From: Laura Gibbons <Laura.Gibbons@arun.gov.uk>
Sent: 27 April 2021 16:28
To: Planning.Responses <Planning.Responses@arun.gov.uk>
Cc: Simon Davis <Simon.Davis@arun.gov.uk>
Subject: RE: Planning Consultation on: Y/47/21/DOC

Application No: Y/47/21/DOC

Site Address: Bonhams Field Main Road Yapton BN18 0DX

Description of Works: Approval of details reserved by condition imposed under Y/1/17/OUT relating to Conditions(s) 12 - Surface Water Drainage Scheme and 14 - Maintenance and Management of SUDS

1210

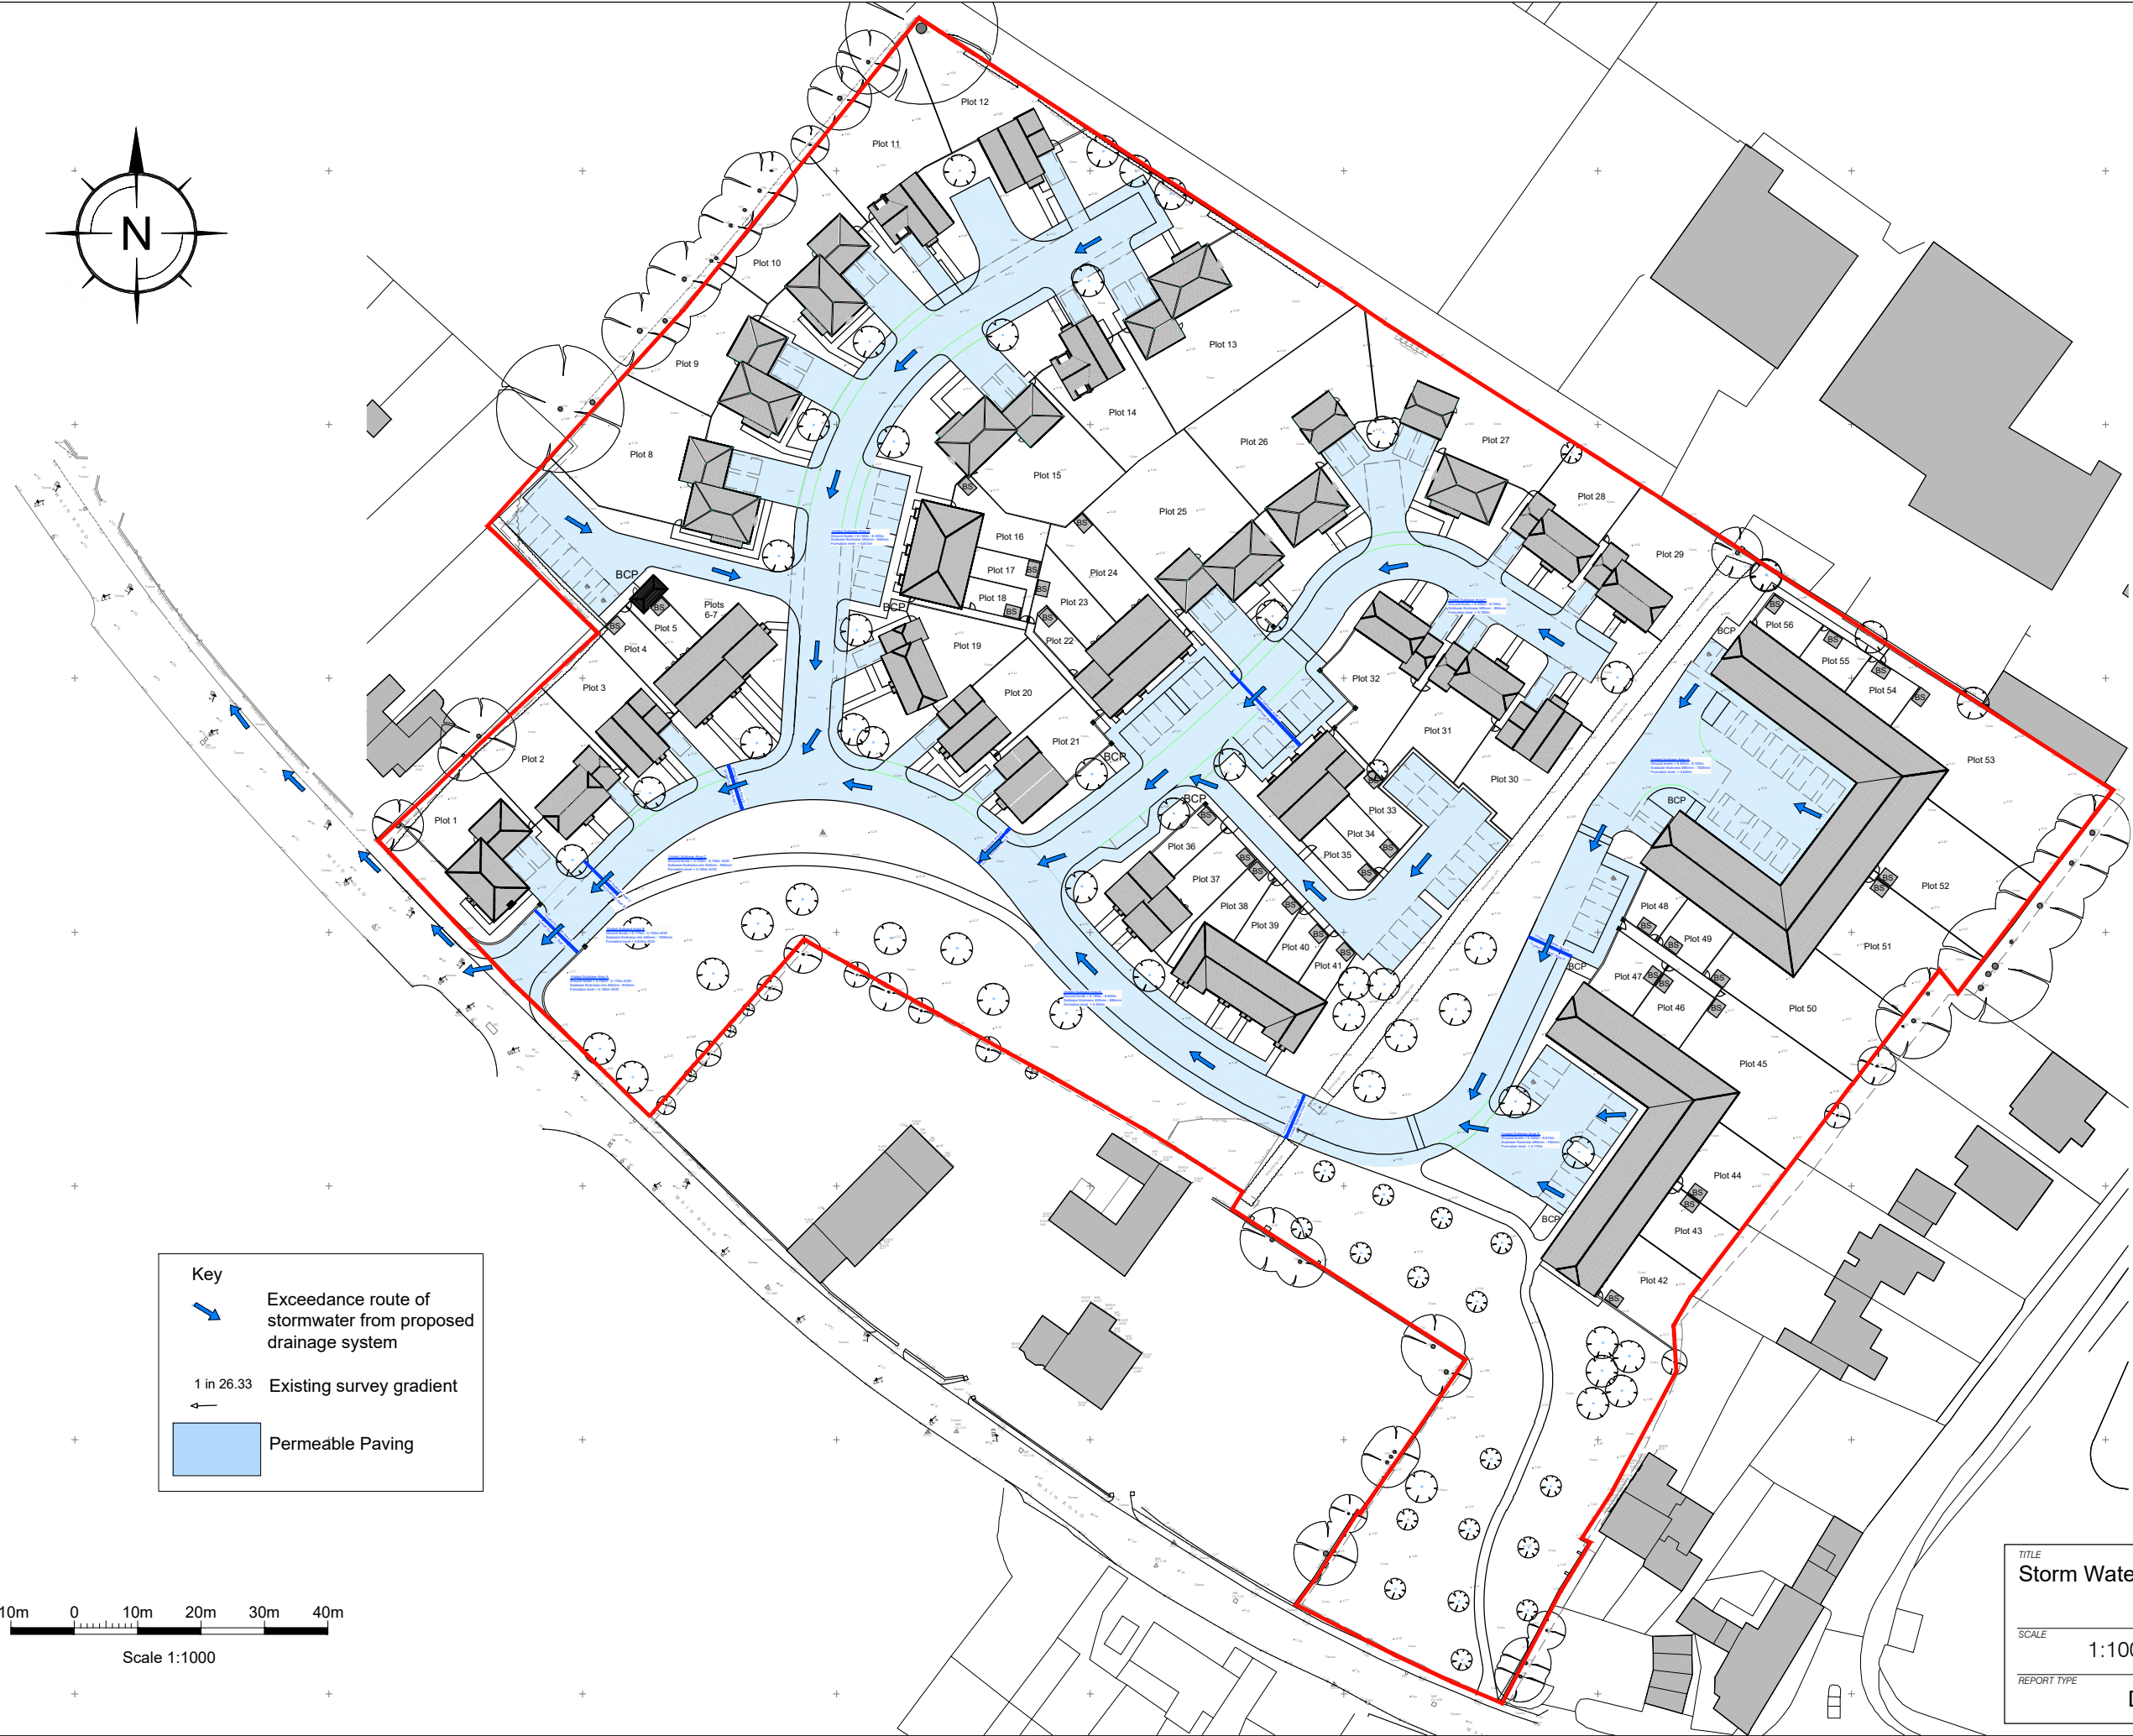
The point of greatest concern is the failure to meet policy requirement for setting incoming invert levels to infiltration structures above the 1 in 10 year plus cc water level (see below summary table). This requirement comes from adopted policy and must be met.

Area	Formation Level	Lowest Invert Level	1 in 10 year plus cc water level	Policy requirement met?
E	5.625	5.75	5.772	No
F	5.78	5.925	5.976	No
G	5.77	5.825	5.97	No
H	5.655	5.90	5.994	No

There appear to be options for the successful resolution of this problem, such as taking some rwp's to soakaways to shorten drain runs and raise up invert levels at discharge locations. The potential for further lowering formation levels should also be investigated, whilst ensuring that formation levels remain above peak seasonal groundwater level.
